Planning Application: 2026/92432
Site: Land adjacent to 46 The Fairway, Fixby, Huddersfield, HD2 2HU
Proposal: Formation of a vehicular access and relocation of existing gates

I wish to formally object to planning application 2026/92432 and request that the application is carefully assessed against the relevant Kirklees Local Plan policies, particularly LP21 – Highway Safety and Access, LP22 – Parking, LP30 – Biodiversity and Geodiversity, LP33 – Trees, LP51 – Protection and Improvement of Local Air Quality and LP52 – Protection and Improvement of Environmental Quality.

Proposed Vehicular Access and
Highway Alterations

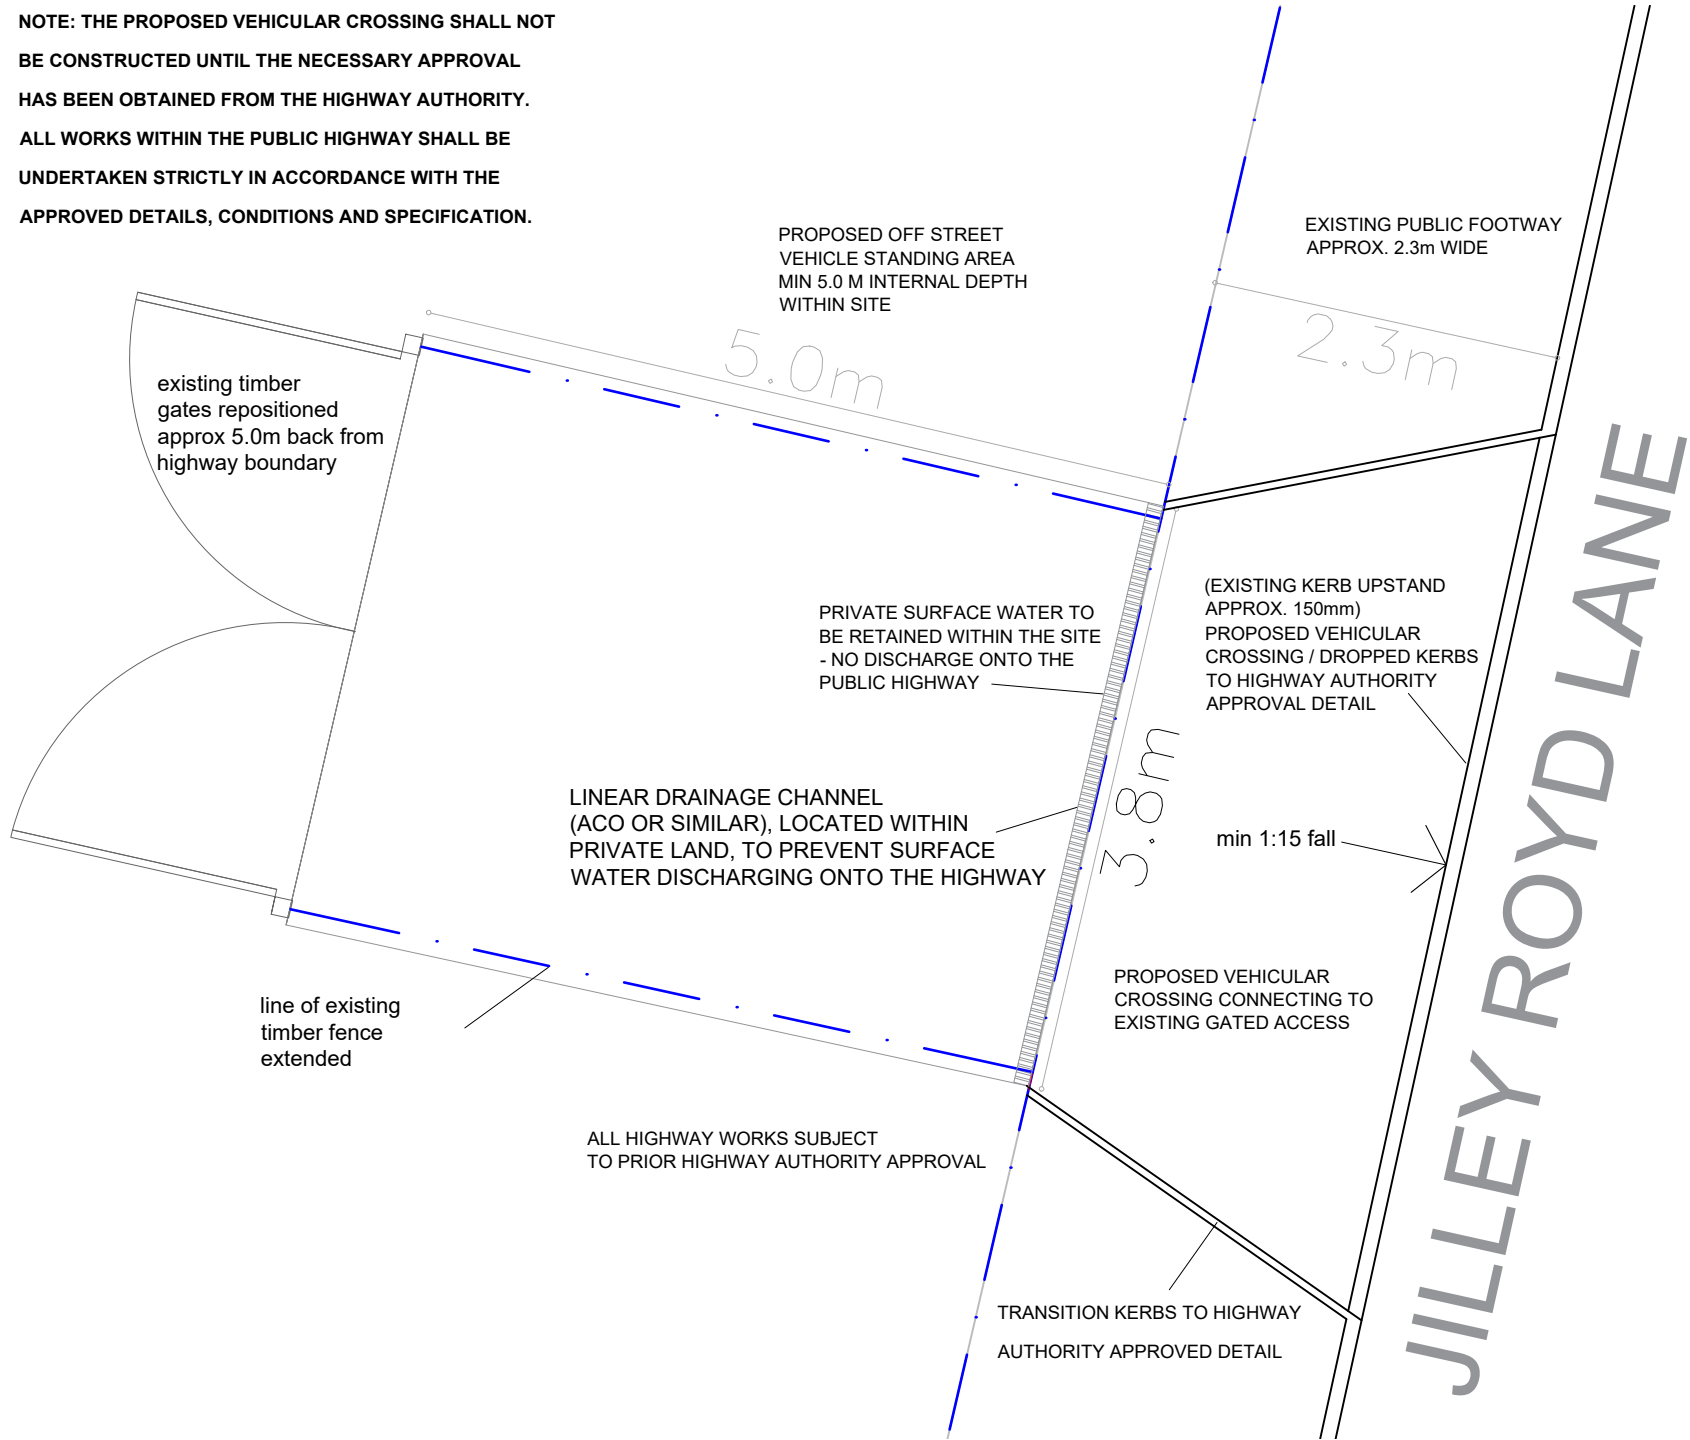
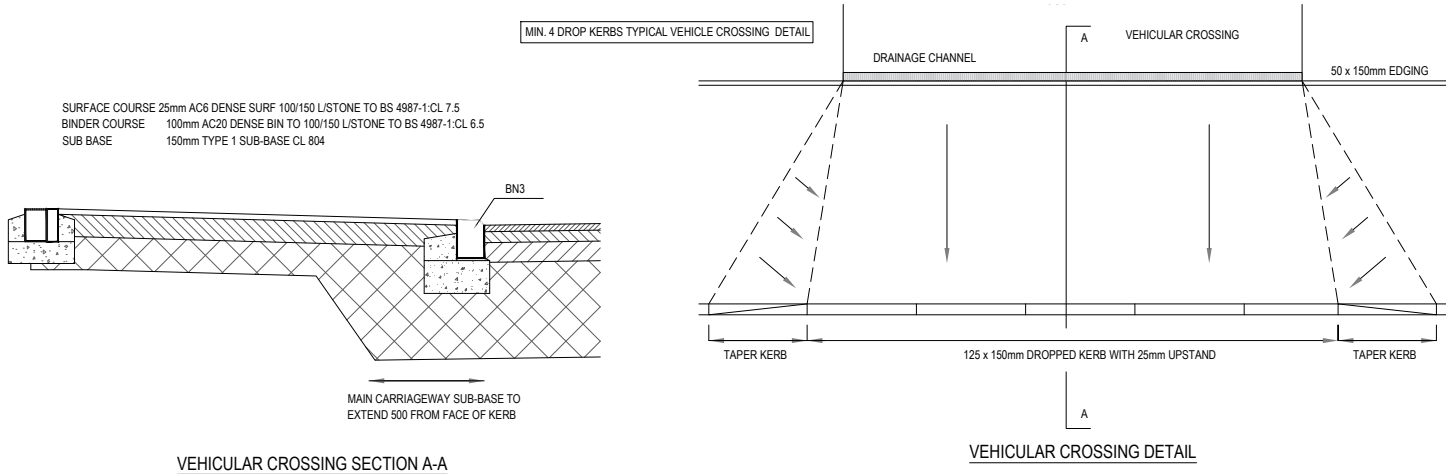
I have significant concerns about the safety implications of the proposed vehicular access.

The creation of an additional vehicular access has the potential to introduce conflict between vehicles entering and leaving the site and pedestrians, cyclists and existing road users.

The location of the proposed access in relation to the existing highway.

Forward visibility for vehicles approaching the access.

Visibility for vehicles emerging from the site.

The required visibility splay and whether it can actually be achieved.

Whether the required visibility can be maintained permanently.

Whether vehicles can enter and leave the site safely without obstructing the highway.

I have particular concerns regarding the proposed visibility splay.

It is not sufficient for a visibility splay to be shown diagrammatically on a plan. The Council must be satisfied that the necessary visibility can physically be achieved on the ground and retained permanently.

What visibility distances are required by the applicable highway standards.

Whether those distances can be achieved from the proposed access.

Whether achieving them would require the removal, pruning or alteration of established vegetation or trees.

Whether any part of the visibility splay falls outside the applicant's ownership or control.

Whether the visibility can be guaranteed and maintained in perpetuity.

I therefore request that the Council specifically establishes whether any trees affected directly or indirectly by the proposed access, visibility splay, construction works or gate relocation are protected by TPO 08/77 or any other tree protection designation.

Excavation required to construct the access.

New hardstanding.
